Our Ref: Y/22/19/PL 15-03-2019

Demolition of existing redundant garage building & erection of 1 No. dwelling and associated works (alternative following Y/68/17/PL). This application may affect the setting of listed buildings & may affect the character & appearance of the Main Road/Church Road, Yapton Conservation Area.

Garage Premises Main Road Yapton

Thank you for your internet representation made on 26th April 2019 which has been recorded as '**an objection**' with the comments as follows:

PROJECT	CLIENT	DATE	DRAWN
Reptune Garage site Main Road YAPTON	P Mountford	Feb 2019	pm
DRAWING	SCALE	DRAWING NO	REV
Proposed sections	1:100@A3	1801/05

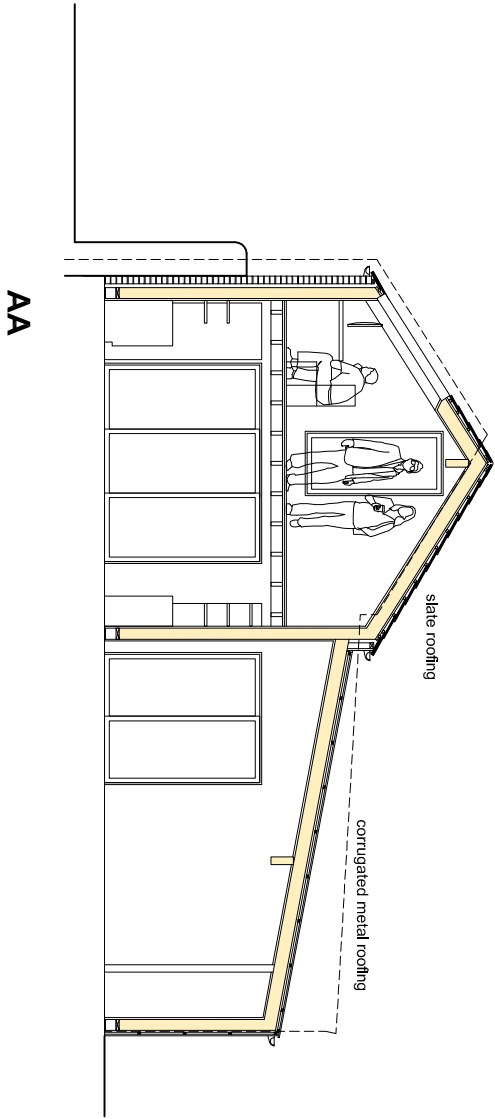
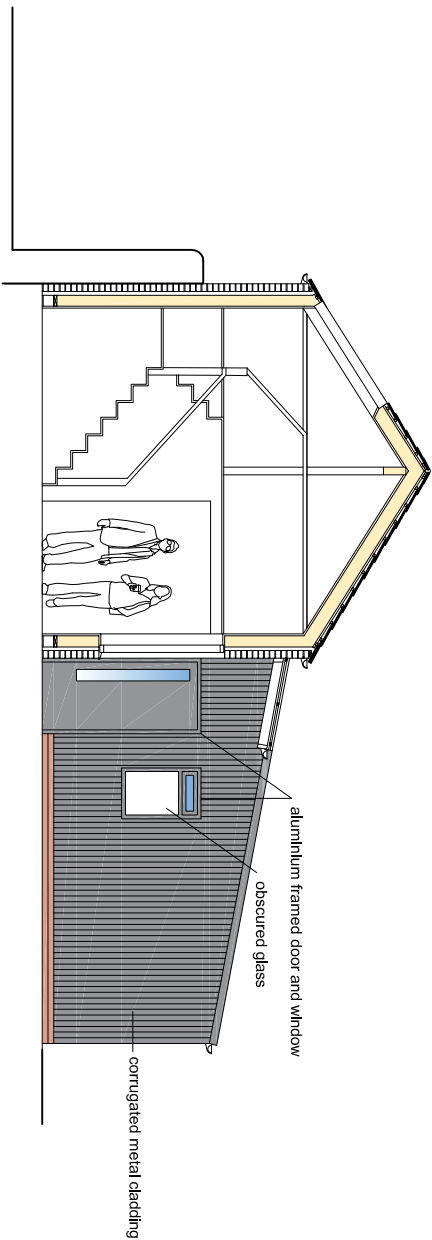
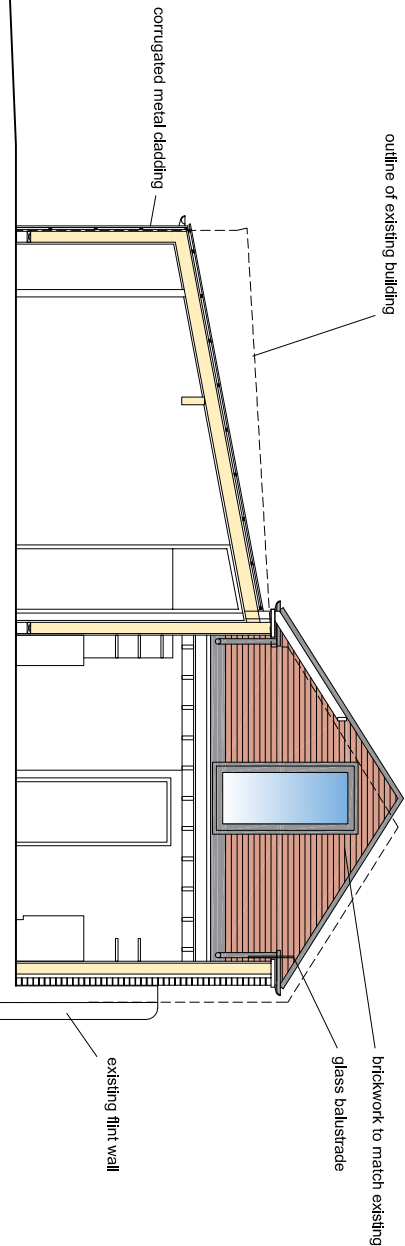
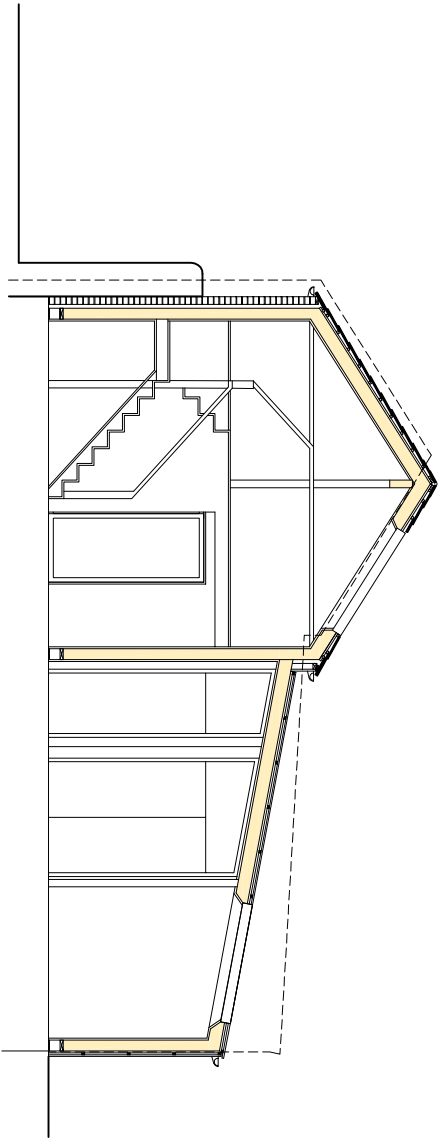
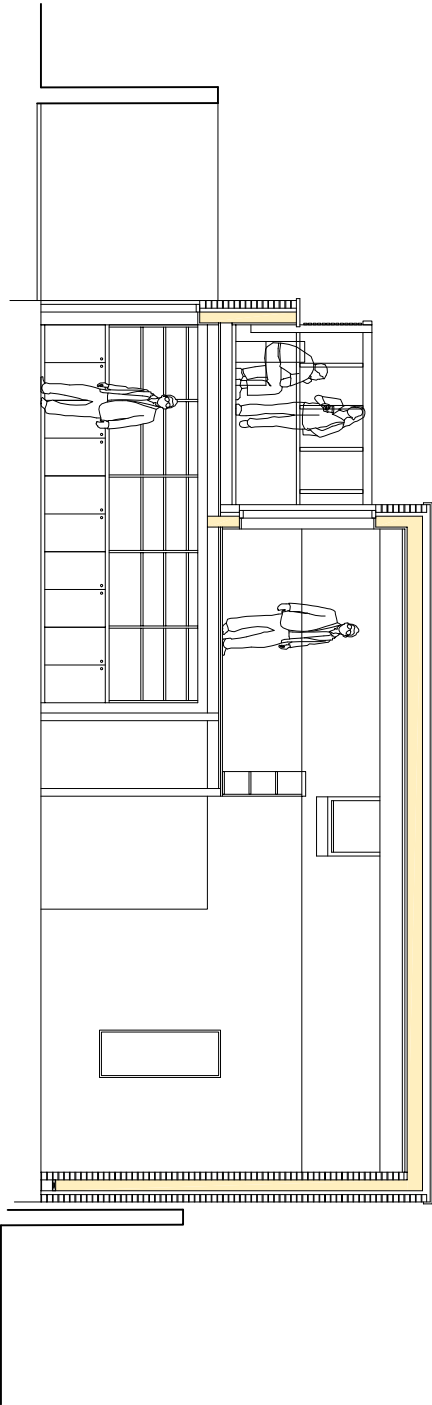
The First floor terrace directly neighbours our garden and though a cedar screen is proposed to obscure the terraces line of sight to the east, it still possess a clear line of sight into are garden and of the back of the house from the north. This combined with the noise pollution it will likely generate. Will have a detrimental impact on our living environment.

We would like to see the terrace removed from the proposal or at minimum appropriate measure taken to ensure that it wouldn't effect our privacy. We would like to see that these requirements are guaranteed in the conditions of planning and enshrined in the deeds, to ensure no future alterations can be made.
